Gatwick Airport Northern Runway Project

Statement of Common Ground Between Gatwick Airport Limited and Tandridge District Council – Clean Version

Application Document Ref: 10.1.9

Diagram 3.3.1: Model performance before and after adjustment, Generic zone

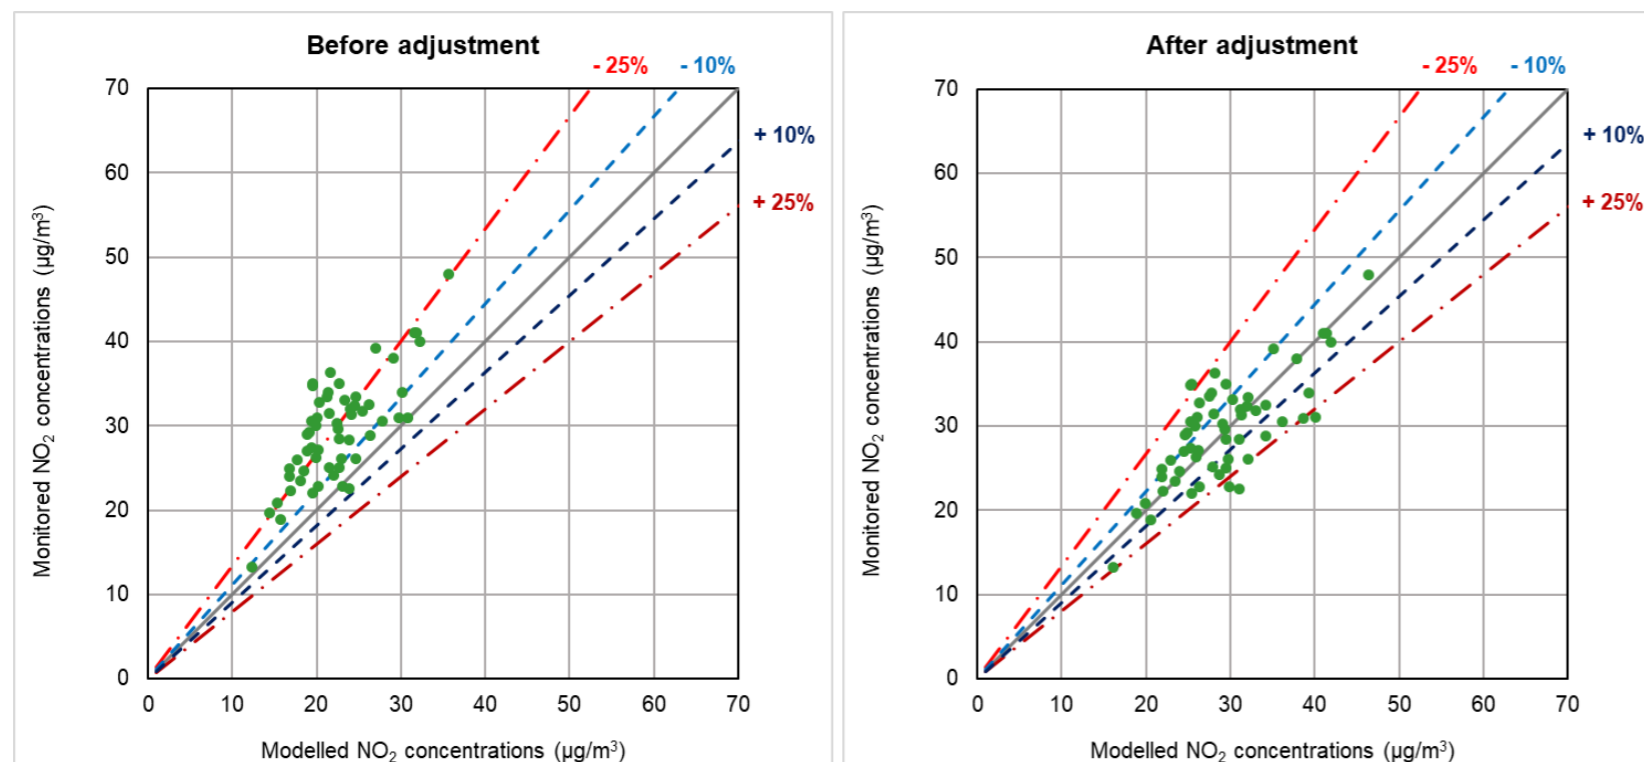
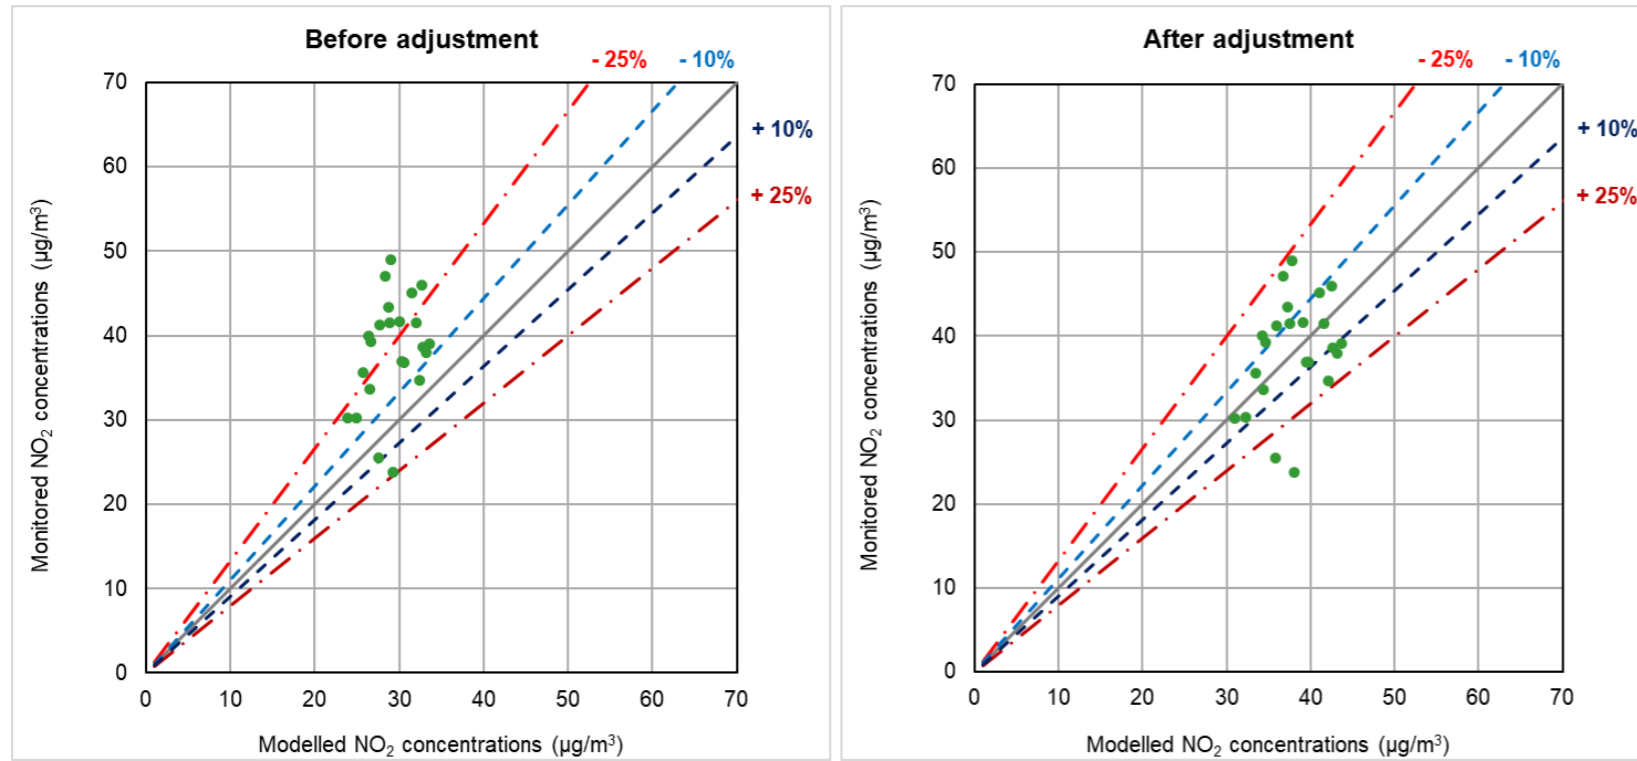
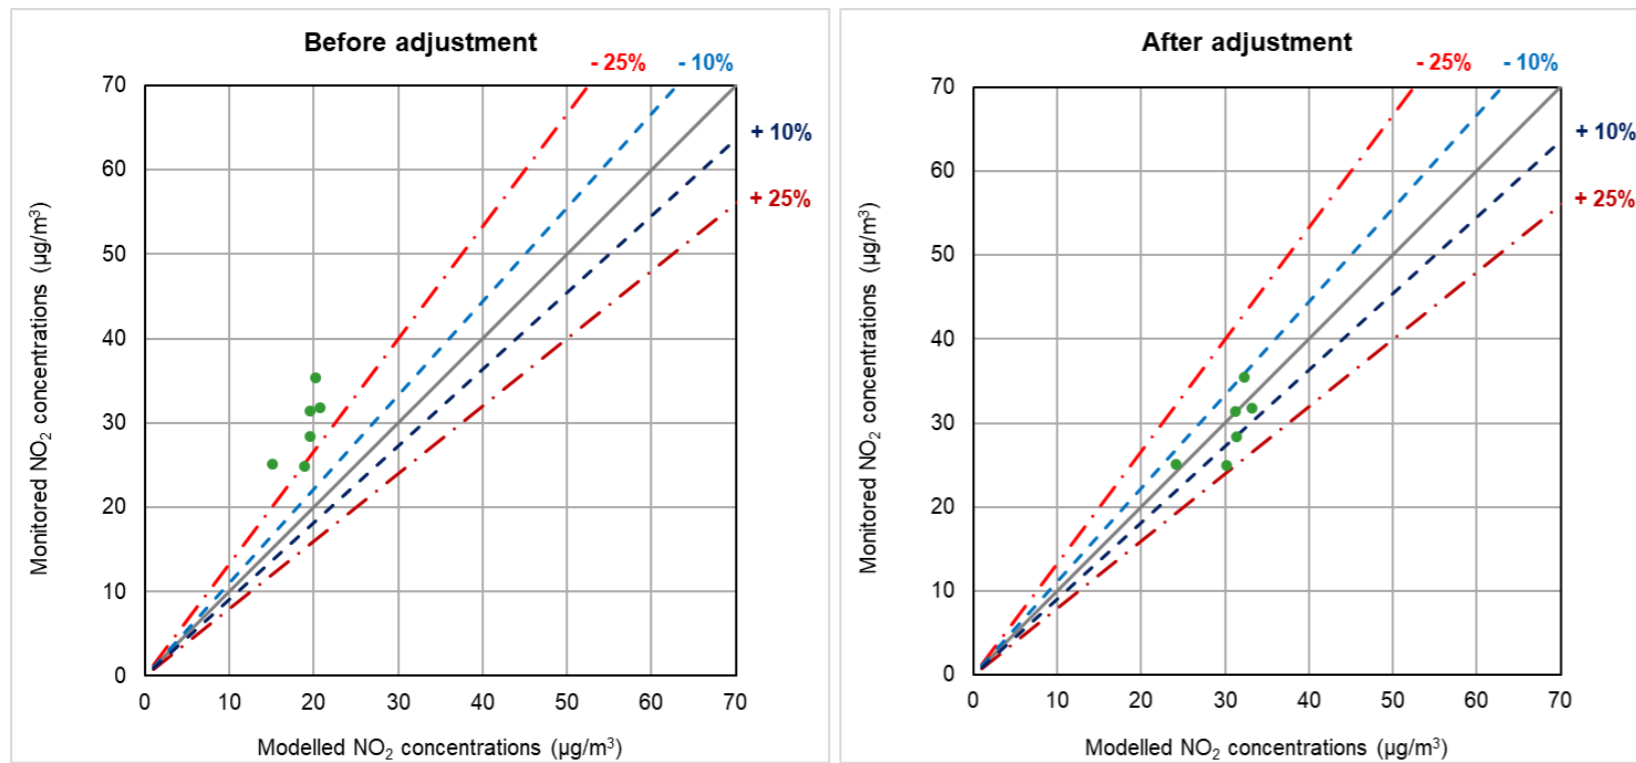
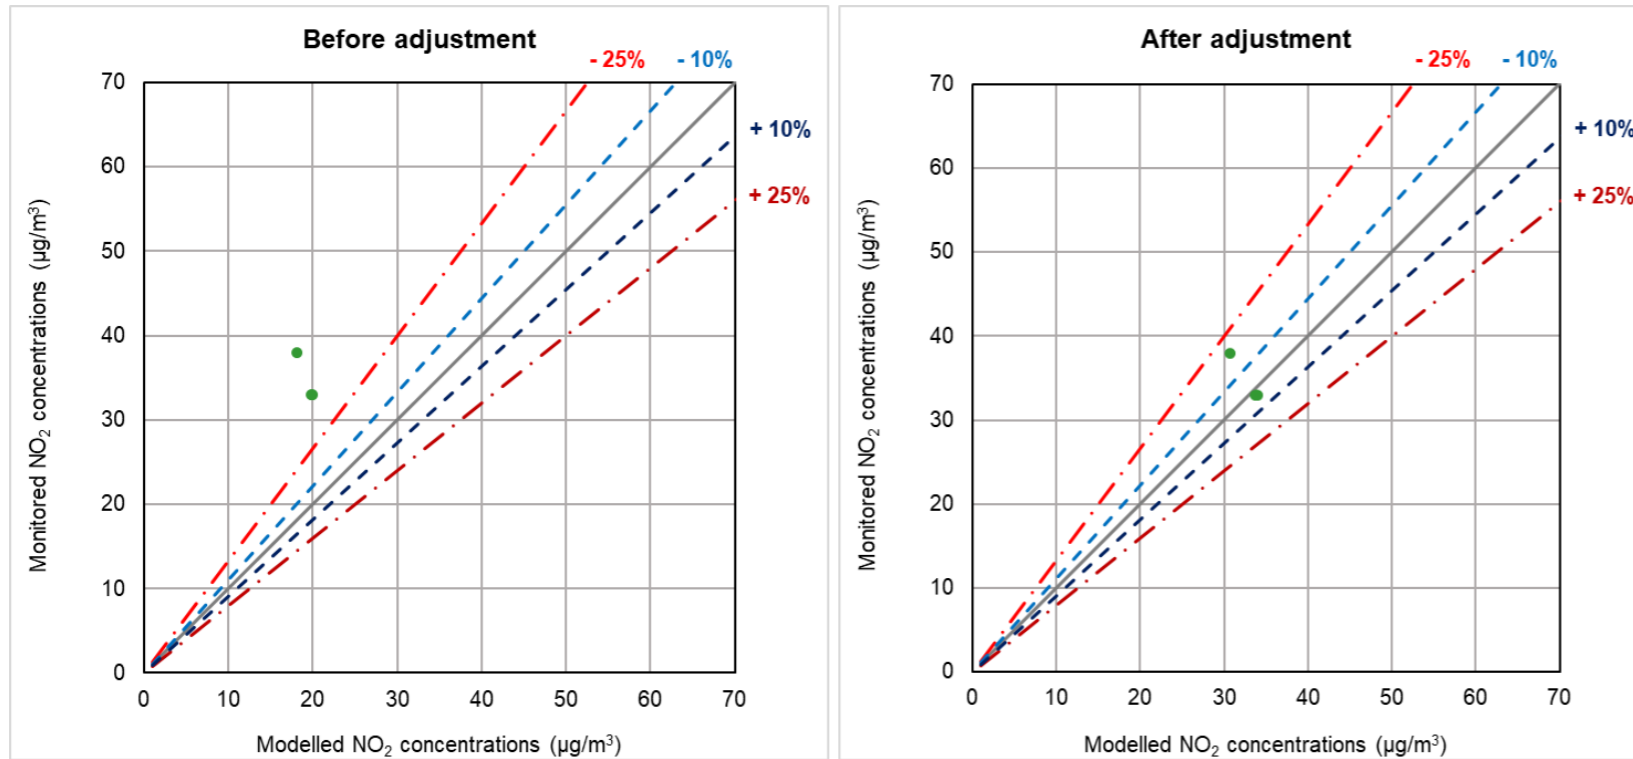
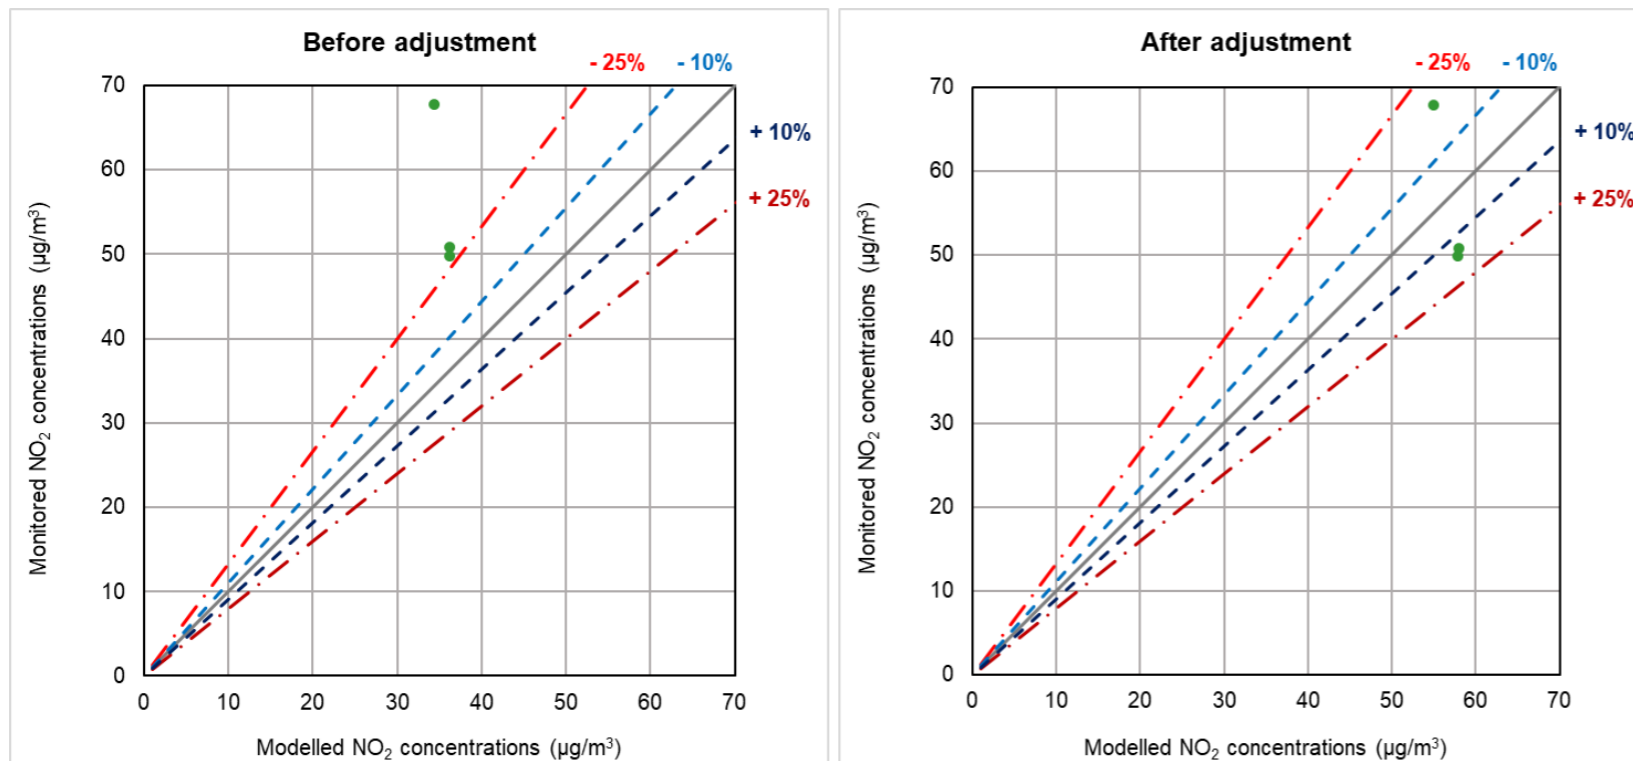
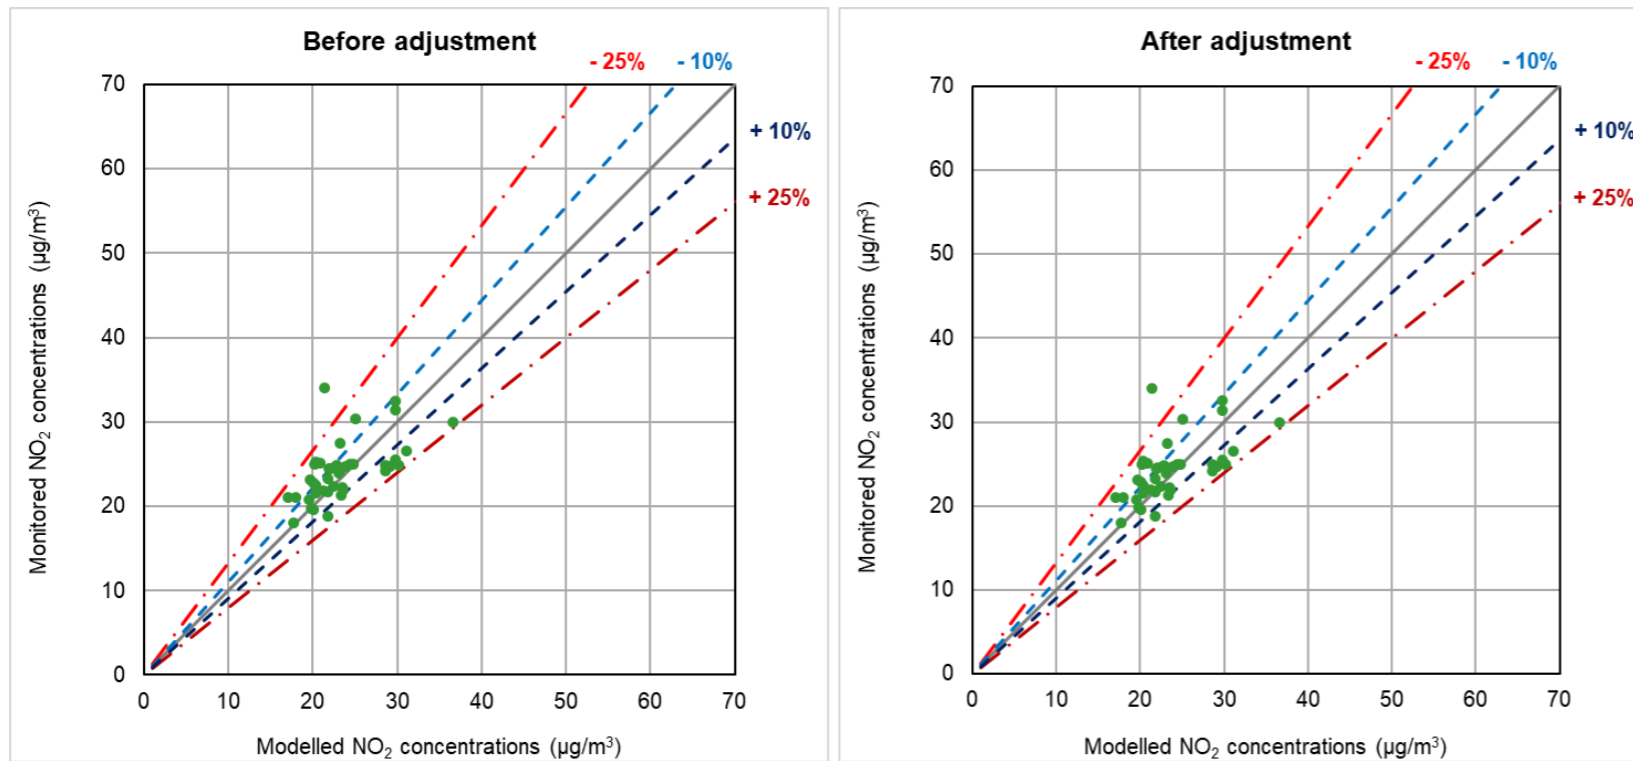
2.2.2.5	Verification zones	<p>TDC disagrees that enough justification was provided for the selection of different verification zones and why the model would be expected to perform differently in each area. A sensitivity test is required to demonstrate that the conclusions of the assessment would not change if a single verification factor were used.</p> <p>Updated position (Deadline 1): Further discussion is required on this point and the request for a sensitivity test examining the use of a single verification factor still remains.</p> <p>Updated position (Deadline 5): Gatwick Airport Limited (GAL) comments in paragraph 3.7.7 of their Response to Deadline 3 Submissions [REP4-031] that the air quality matters submitted by the Joint Local Authorities at Deadline 3 (Appendix A) [REP3-117] will be responded to by Deadline 5. This Appendix of air quality queries prepared by AECOM included a wide range of technical matters.</p>	<p>Full details of the model verification process are included in Section 3 within the ES Appendix 13.6.1. Table 3.3.1 provides details on the verification zones used.</p> <p>The verification methodology was agreed with local councils at the modelling methodology workshop in November 2022. Model files and results were provided to the TWG via email 18th August 2023.</p> <p>The process followed during the ES took into account feedback from the local authorities at the PEIR stage and following discussions on the agreed approach.</p> <p>Updated position (April 2024): The Applicant notes that the JLAs have provided a submission on air quality at Deadline 3. The Applicant will review this submission and respond accordingly.</p> <p>Updated position (Deadline 5): The Applicant has provided a response to the air quality matter submitted by the JLAs at Appendix A: Response to West Sussex Joint Local Authorities – Air Quality to The Applicant’s Response to Deadline 4 Submissions (Doc Ref. 10.38). The Applicant will respond at Deadline 6 to the JLAs’ review submitted at Deadline 4 [REP4-053].</p> <p>Updated Position (July 2024): This matter can be marked as ‘agreed’ following consultation with AECOM on behalf of the local authorities on the technical queries set out at Deadline 5 [REP5-073].</p>	<p>ES Appendix 13.6.1 Air quality Data and Model Verification [APP-159],</p> <p>Appendix A: Response to West Sussex Joint Local Authorities – Air Quality to The Applicant’s Response to Deadline 4 Submissions [REP5-073]</p>	Agreed
